Rezoning Transportation Analysis

Petition Number: 2020-165

General Location Identifier: Tax ID 02516105.

Date	Description
12-28-20	First Review (EL)
1-21-21	Second Review (EL)

SCHEMATIC SITE PLAN

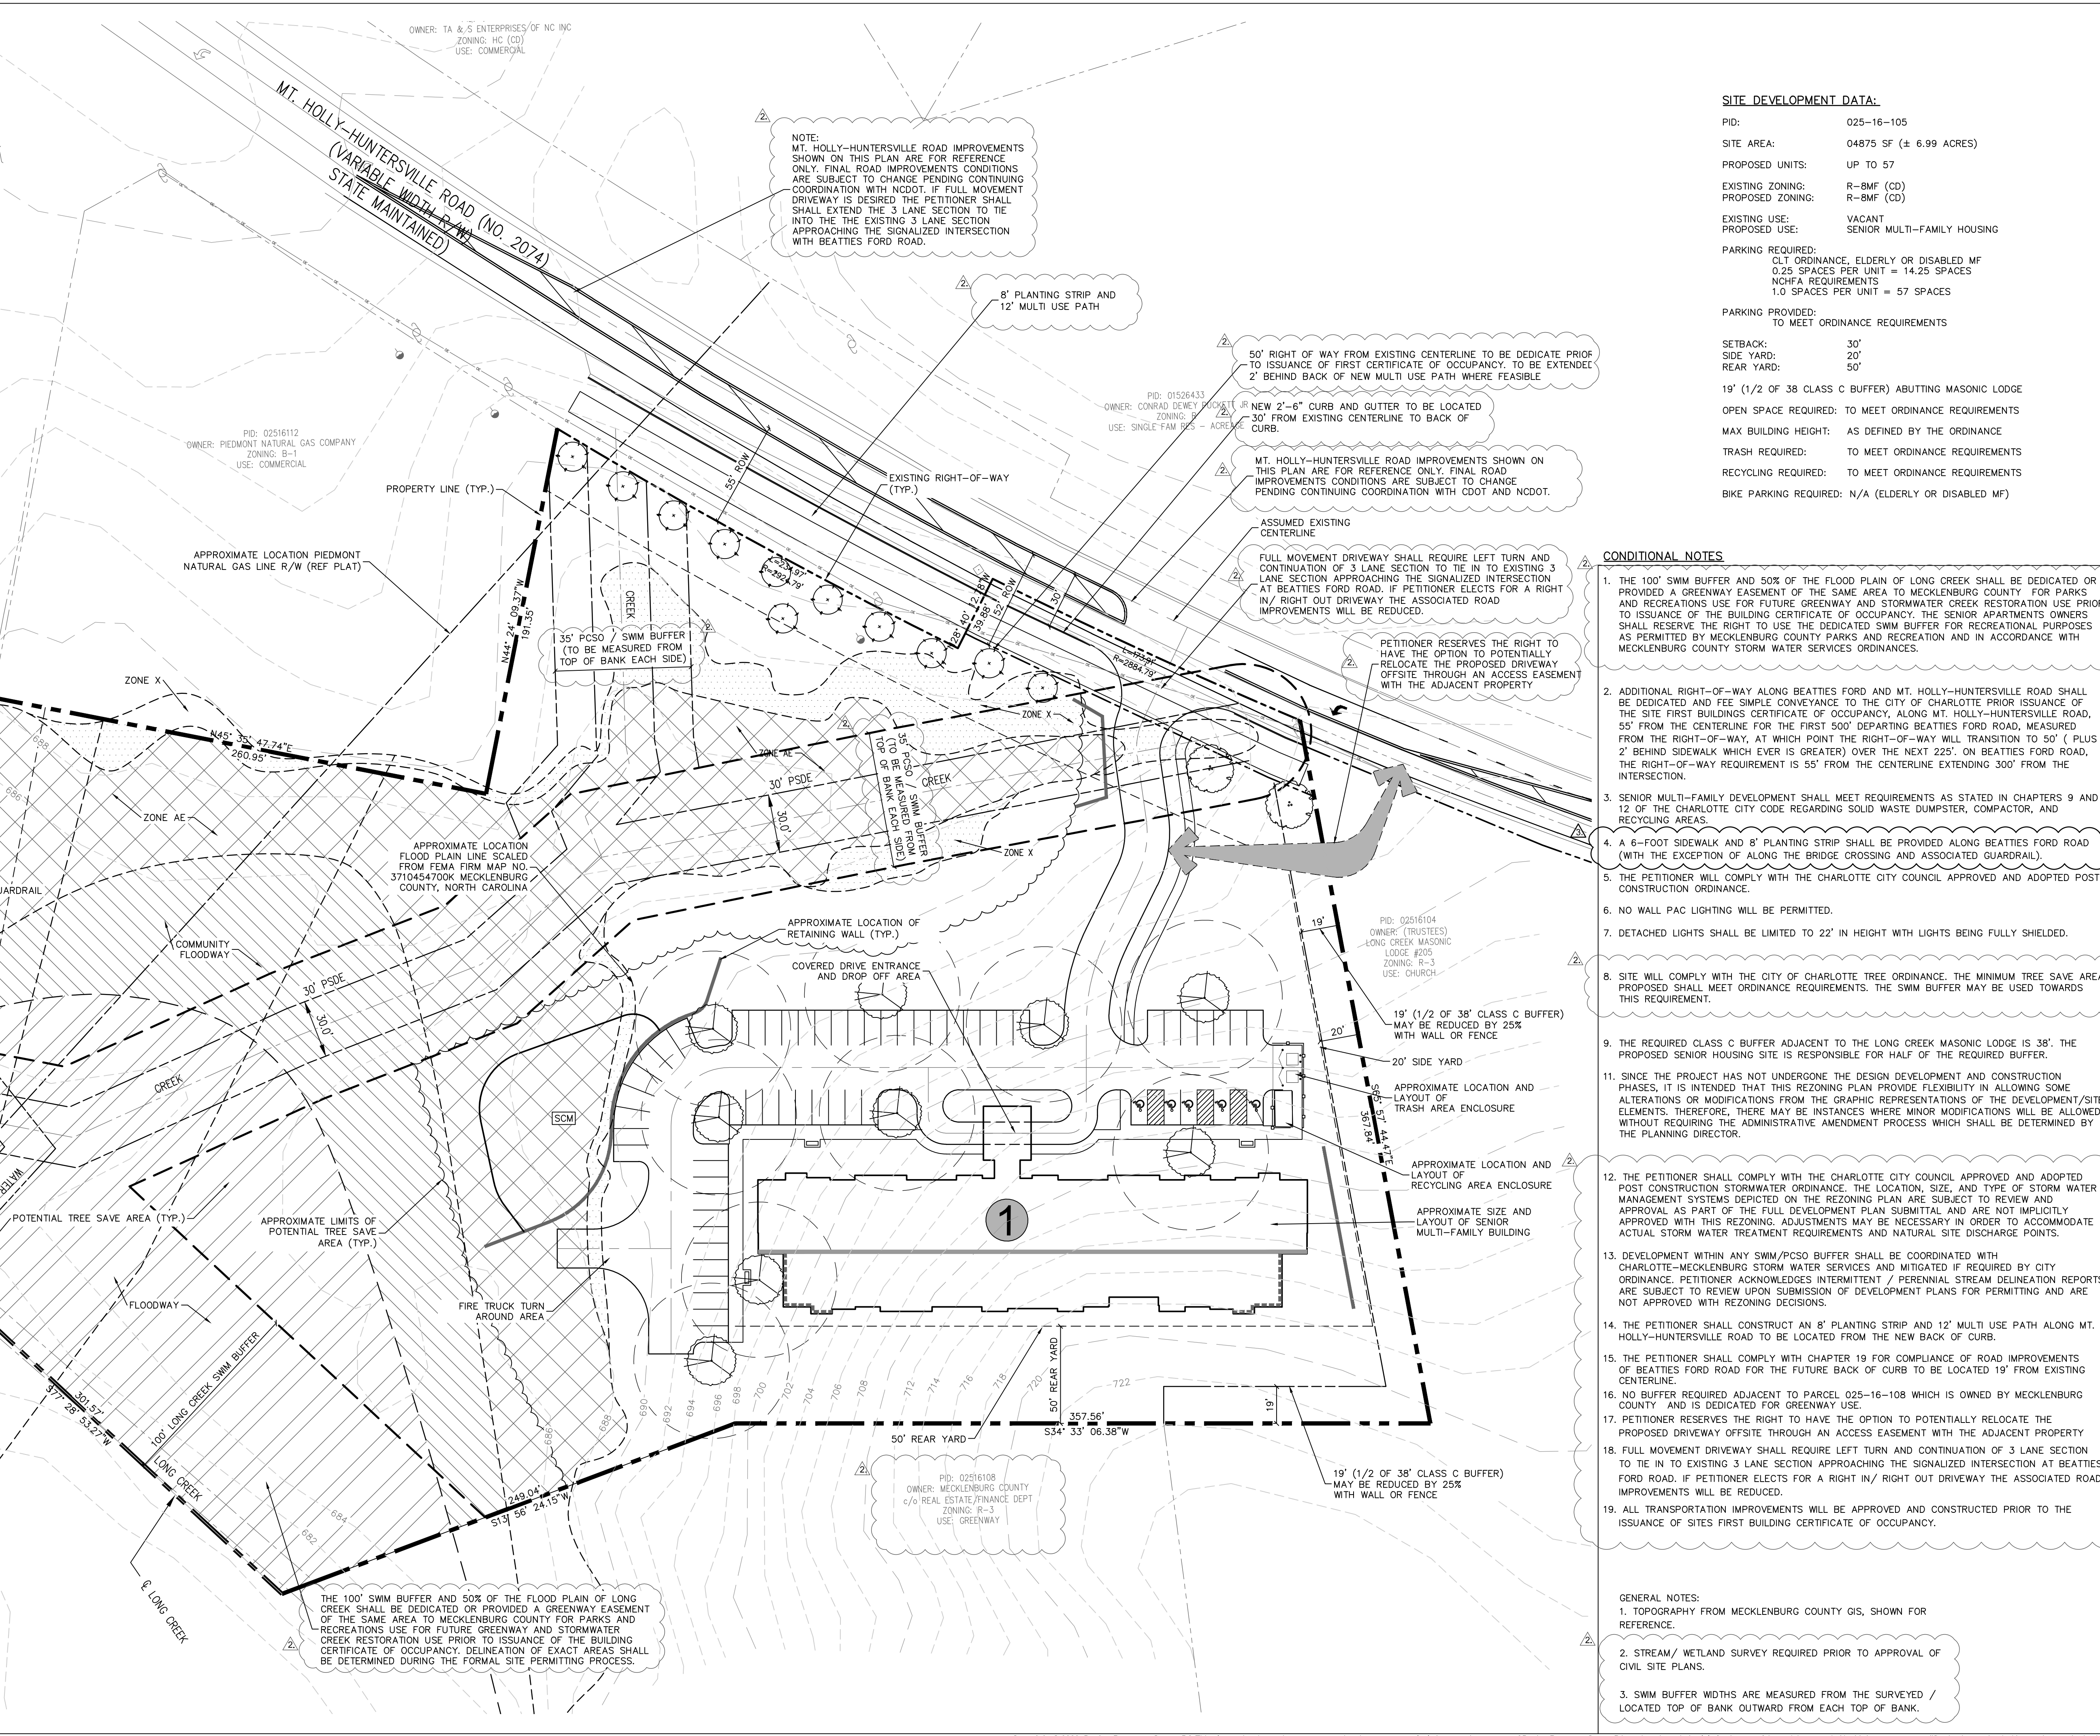
4. A ~~5'~~ FOOT SIDEWALK AND 8' PLANTING STRIP SHALL BE PROVIDED ALONG ~~M.H.H.~~ HOLLY HUNTERSVILLE ROAD FRONTAGE AND BEATTIES FORD ROAD (WITH THE EXCEPTION OF ALONG THE BRIDGE CROSSING AND ASSOCIATED GUARDRAIL).

Remove; MHH will have a 12' MUP per note 14

SCHEMATIC  
 SITE PLAN

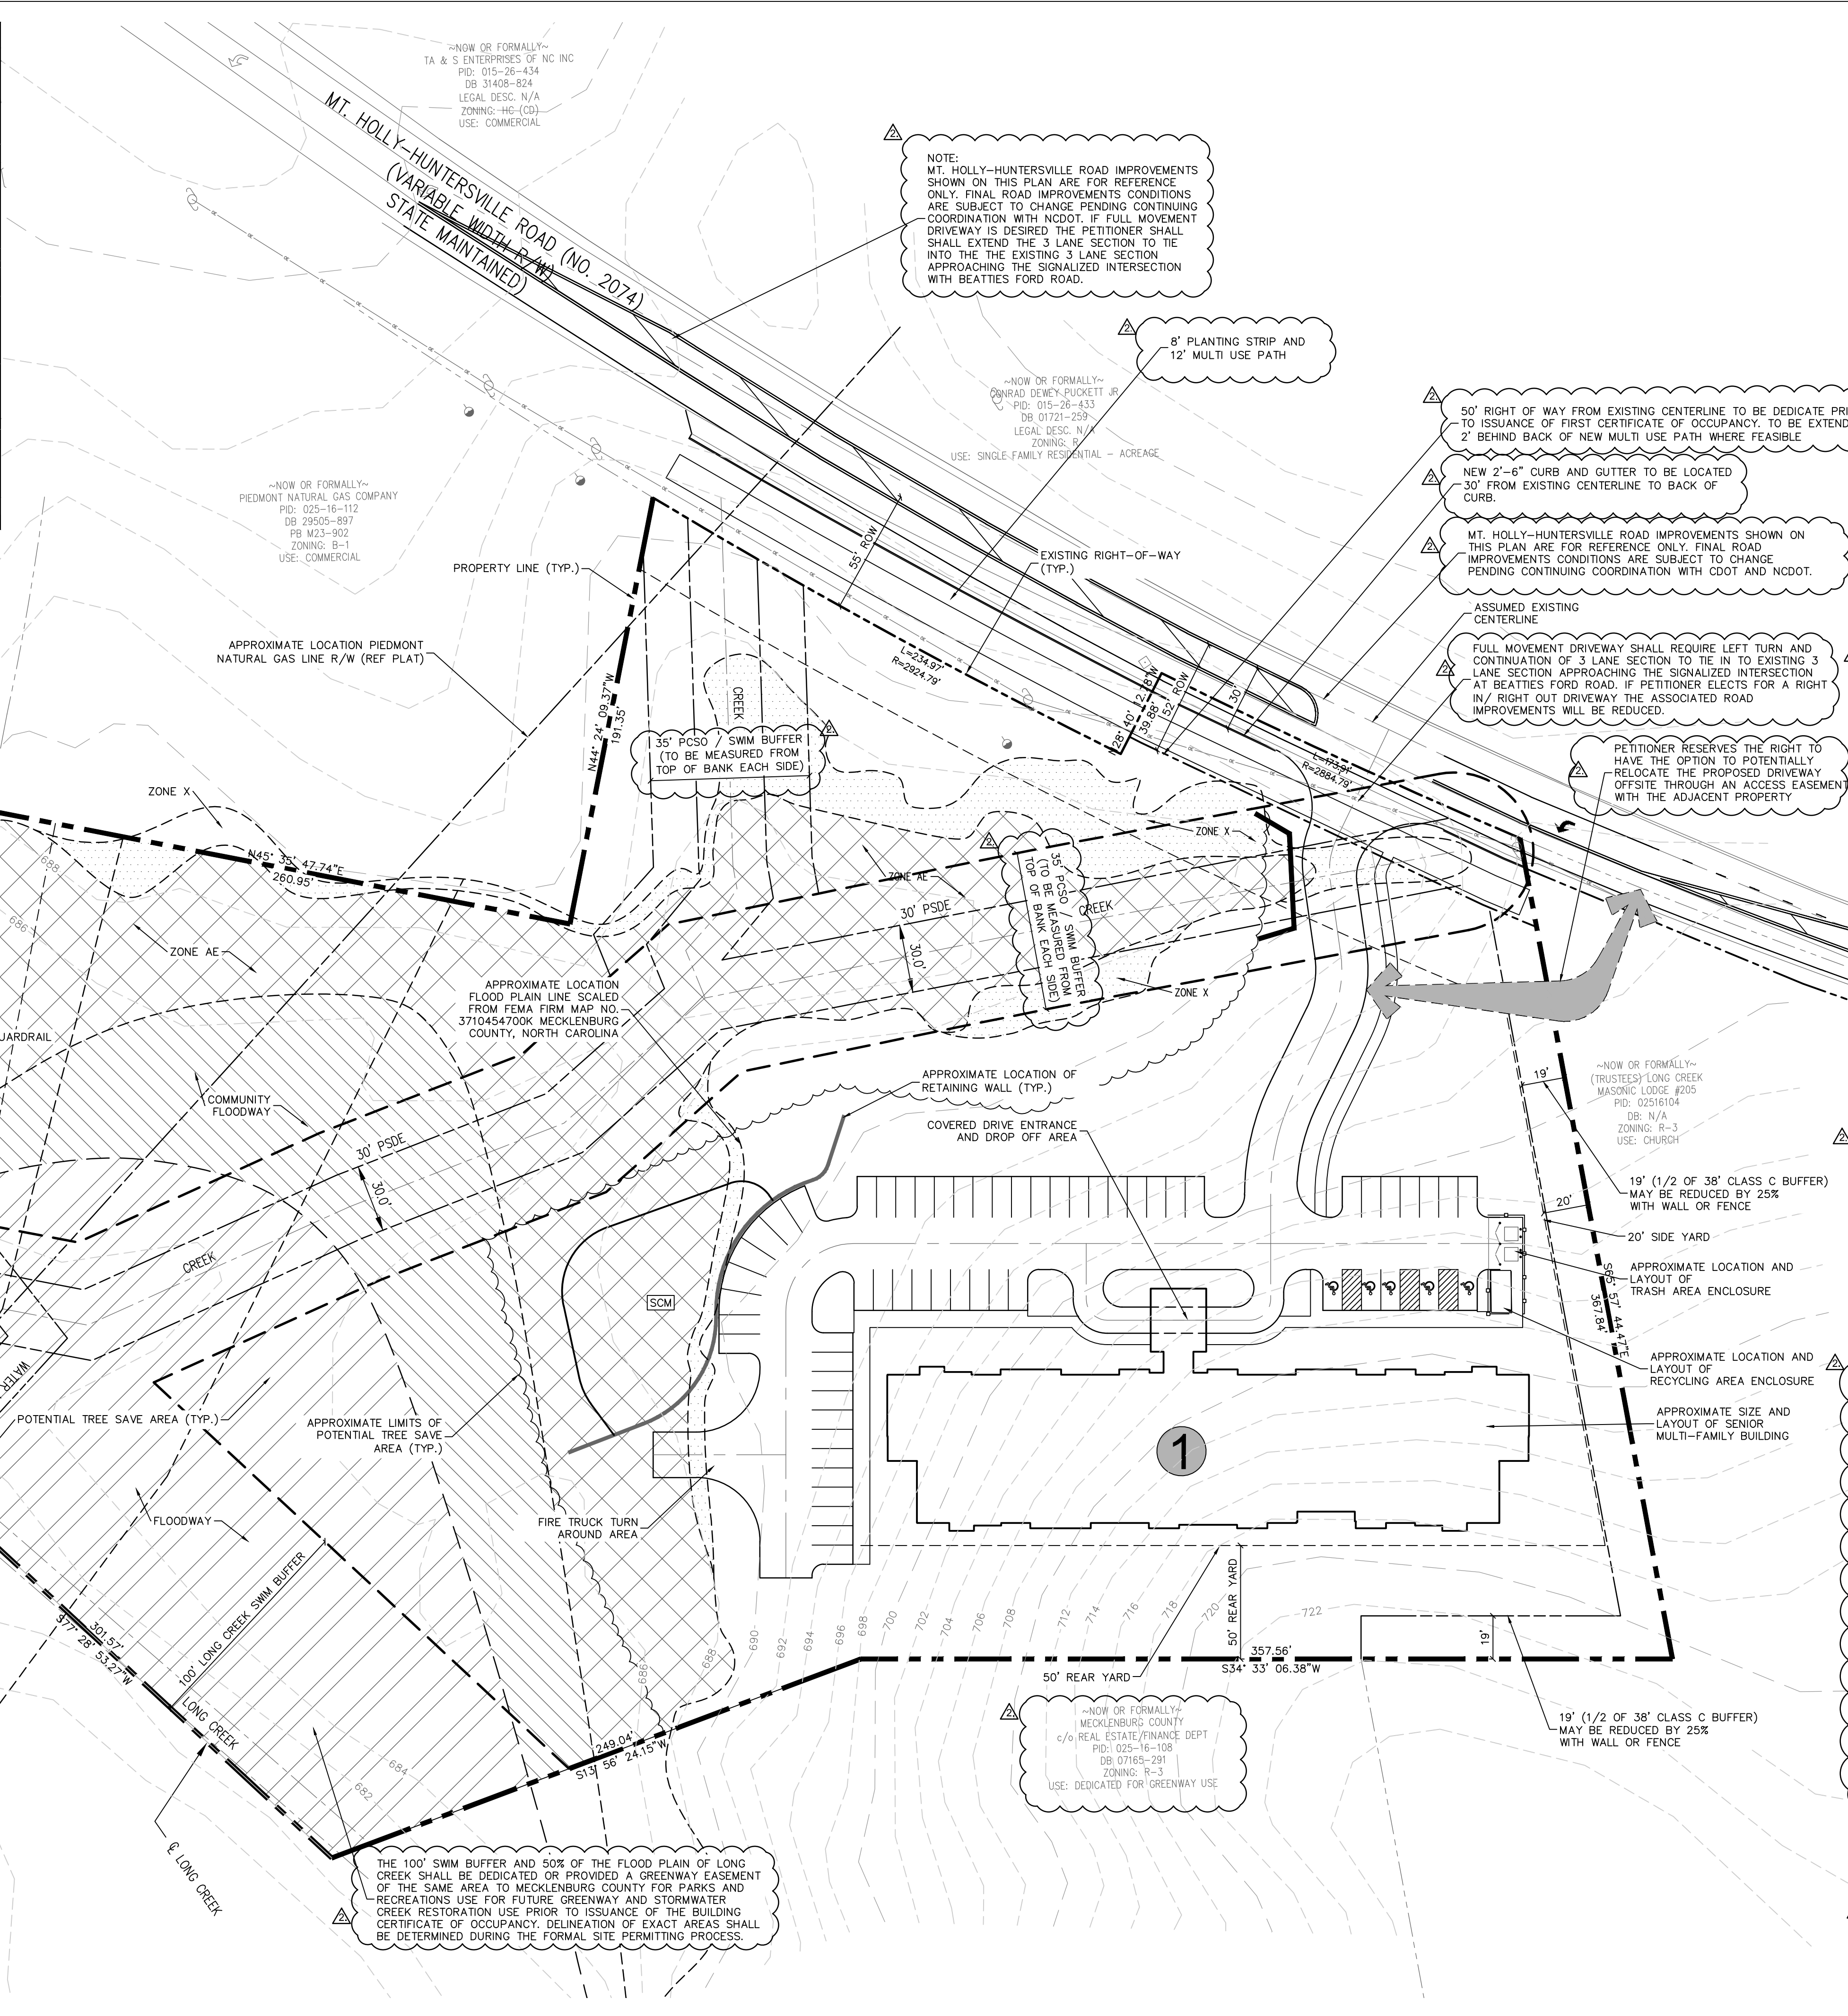
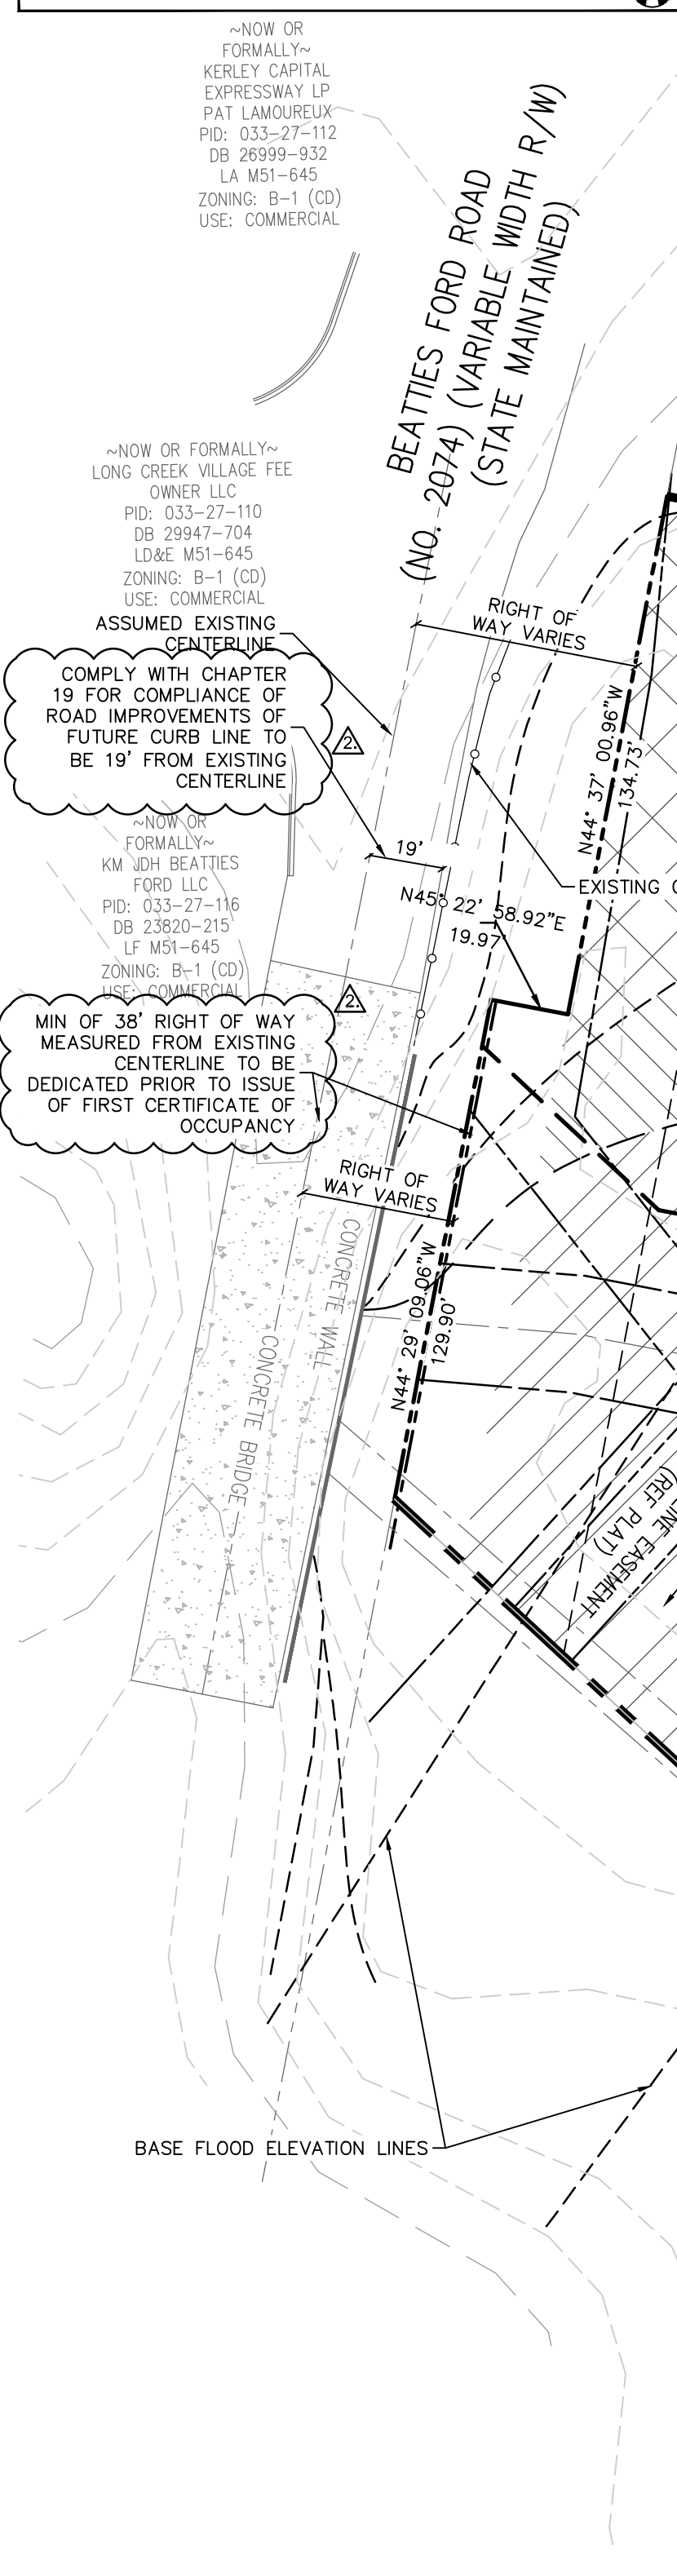
9. ~~A site plan note(s) specifying dedication and fee simple conveyance of all rights-of-way to the City before the site's first building certificate of occupancy is issued is needed. CDOT requests rights-of-way set at 2' behind back of sidewalk where feasible.~~
10. ~~A site plan note specifying that all transportation improvements will be approved and constructed before the site's first building certificate of occupancy is issued is needed. The petitioner may phase transportation improvements if said improvements and phasing are explicitly described in site plan notes.~~
11. **New Comment** (site plan dated 1.11.2021) Site plan and conditional note (4) revisions are needed to clarify the following conditional note corrections, shown below.

12 OF THE CHARLOTTE CITY CODE REGARDING SOLID WASTE DUMPSTER, COMPACTOR, AND RECYCLING **6'** AS.
